OXFORDSHIRE COUNTY COUNCIL'S RESPONSE TO CONSULTATION ON THE FOLLOWING DEVELOPMENT PROPOSAL

Application no: 15/00760/F-3

Location: North And South Arcade At Bicester Eco Town Exemplar Site Charlotte Avenue Bicester

Transport

Rendered Landscape Masterplan

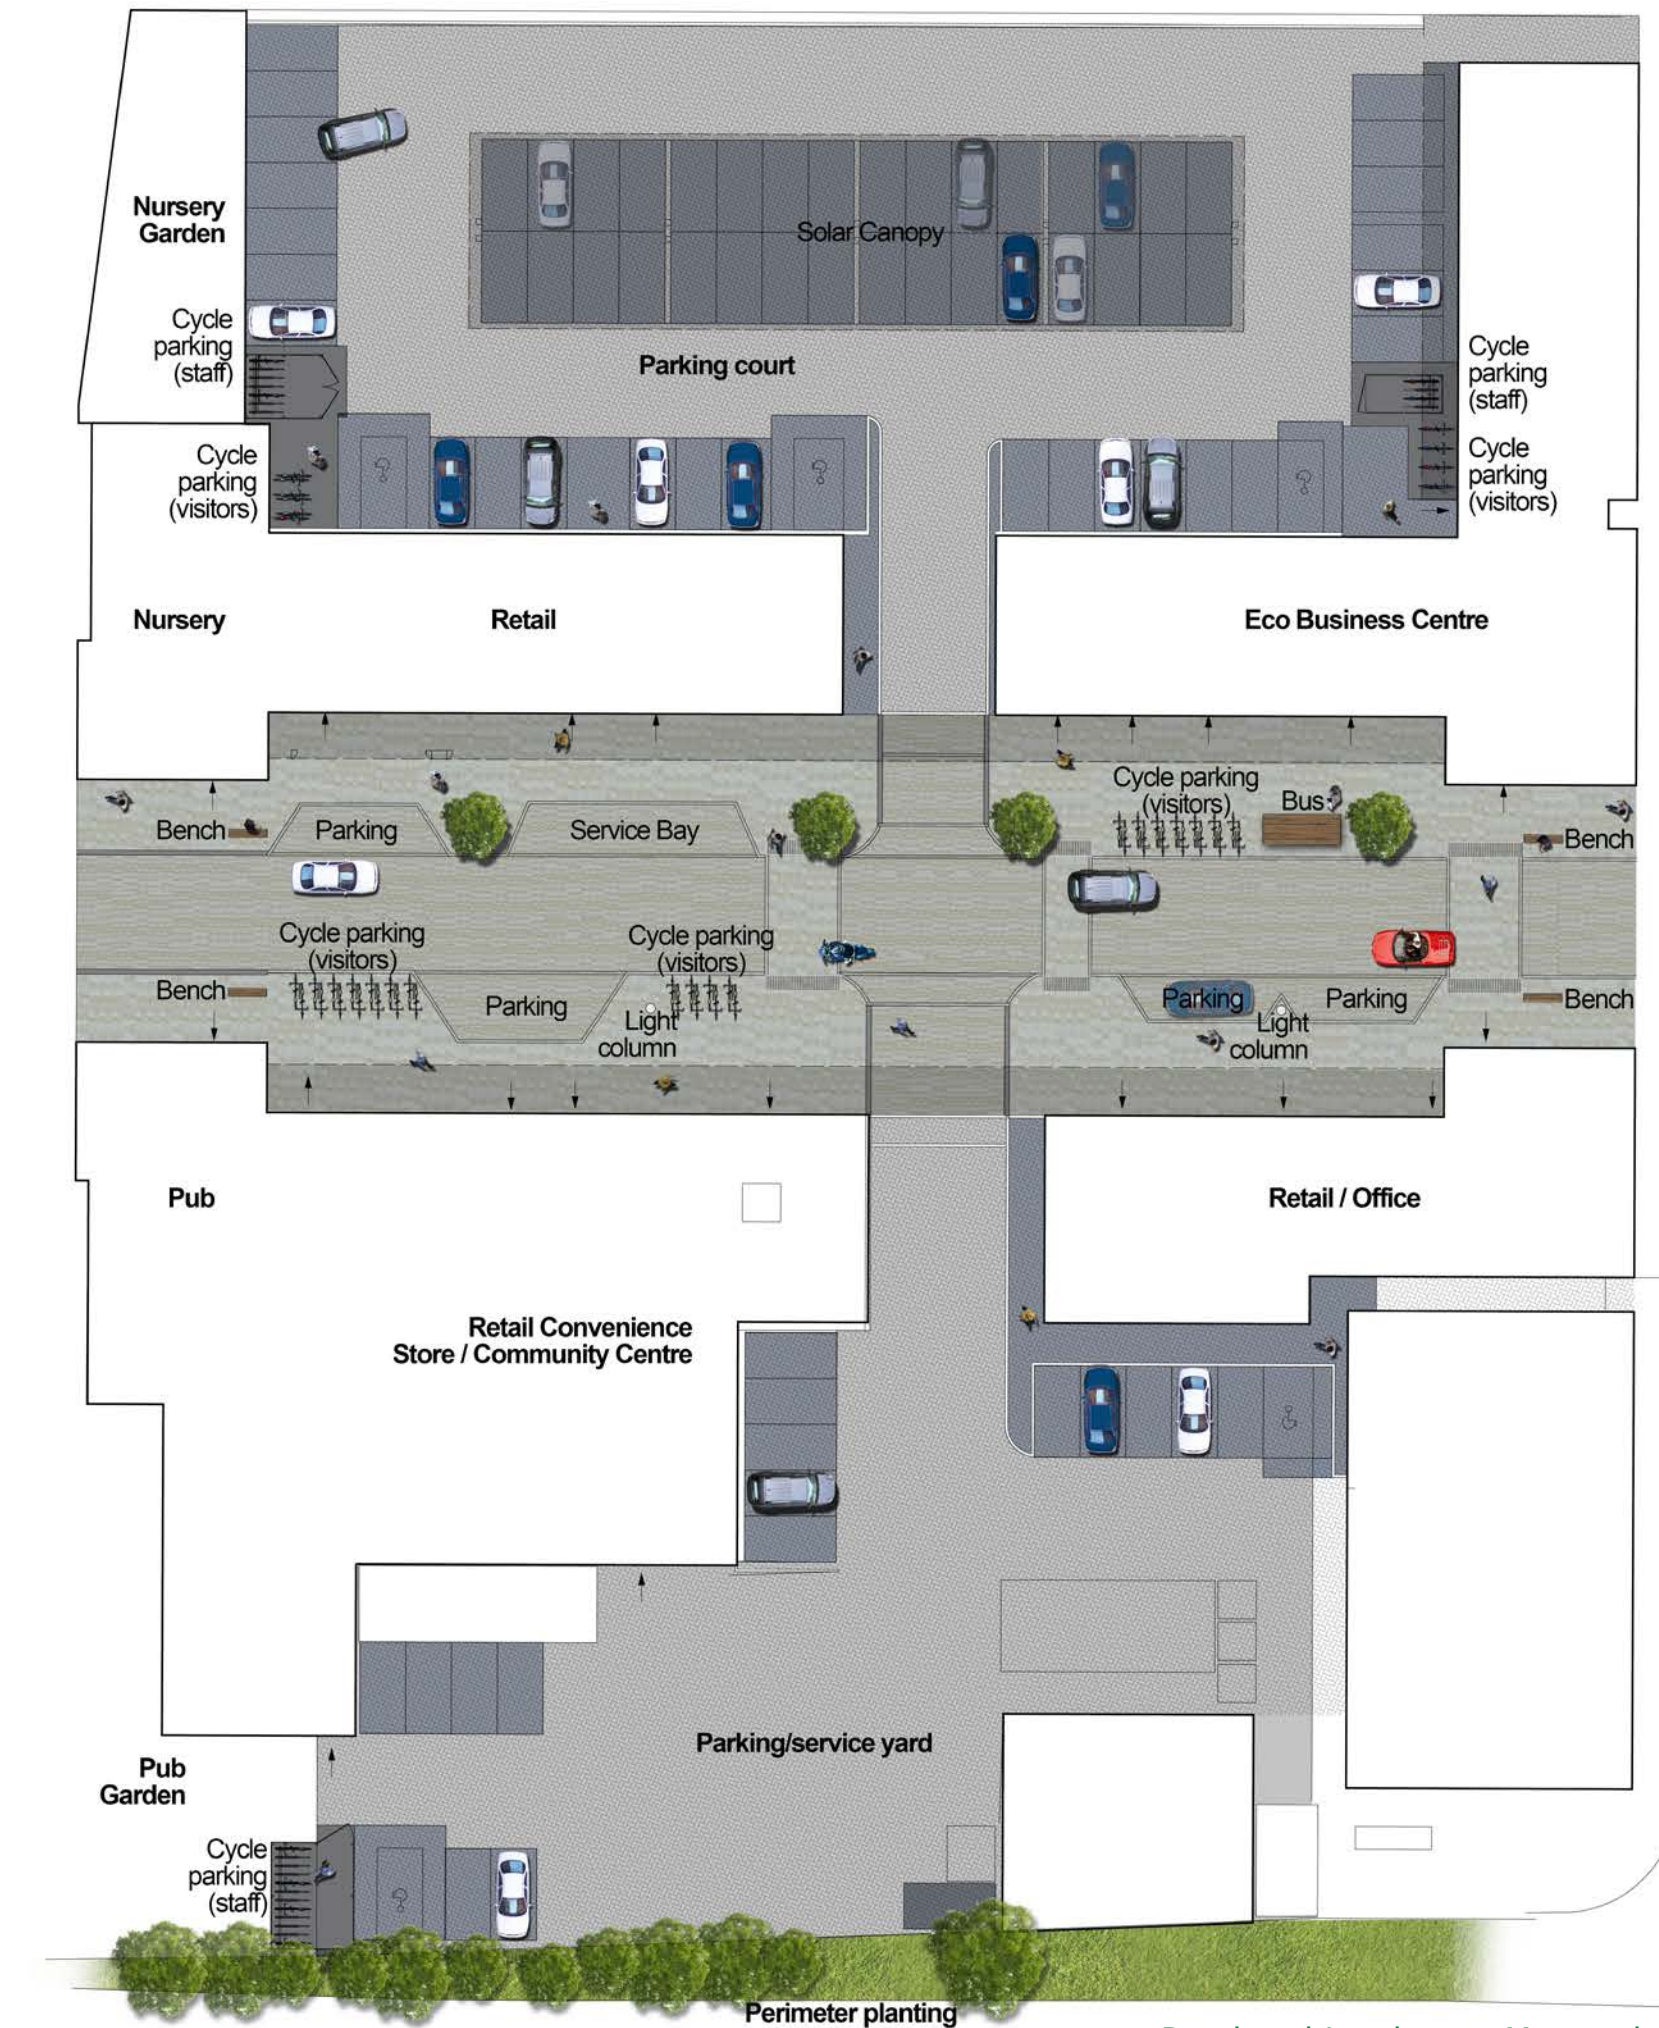
The first thing to note is that the spine road for the Exemplar Site is covered by an existing Section 38 agreement (road adoption), which specifies the design and materials namely coloured asphalt for the footways and black asphalt for the carriageway. The planning application would need to reflect what has been legally agreed within the Section 38 both in terms of materials and layout in light of this there are also significant changes in the layout with on street parking, additional trees and benches being introduced.

What have also been omitted from the layout scheme are the open drainage channels in the local centre area to the south of the spine road at the road edges.

The 'formal' crossing points in fact appear to be informal. Also they only show a change in paving element size rather than a change in colour. Unless there is significant contrast in the road surface colour or some other warning, vehicle drivers will assume priority. They need to be very clearly differentiated or not marked on the carriageway at all. Particularly given the HGV use, it is preferable to see them further away from the turning into the service yard/car park.

The paving appears to be flush all the way across the adoptable areas. Kerb upstands would help prevent parking outside the designated bays and if there are no upstands some bollards or other deterrent may be required to prevent vehicles accessing the non-vehicular areas.

The proposed public car parking space (disabled space) outside the convenience store is too wide which doesn't leave much space for an adoptable footway immediately adjacent to it. The width of this space should be reduced to 3m width which should leave at least 2m for the footway adjacent to it.

The proposed street design would need to be the subject of a revision to the S38 agreement, which would require further technical audit. It would be helpful for the applicant to confirm the areas proposed to be offered for adoption at this time. The submitted drawings appear to indicate a colonnade on both sides – areas underneath this will not be adopted.
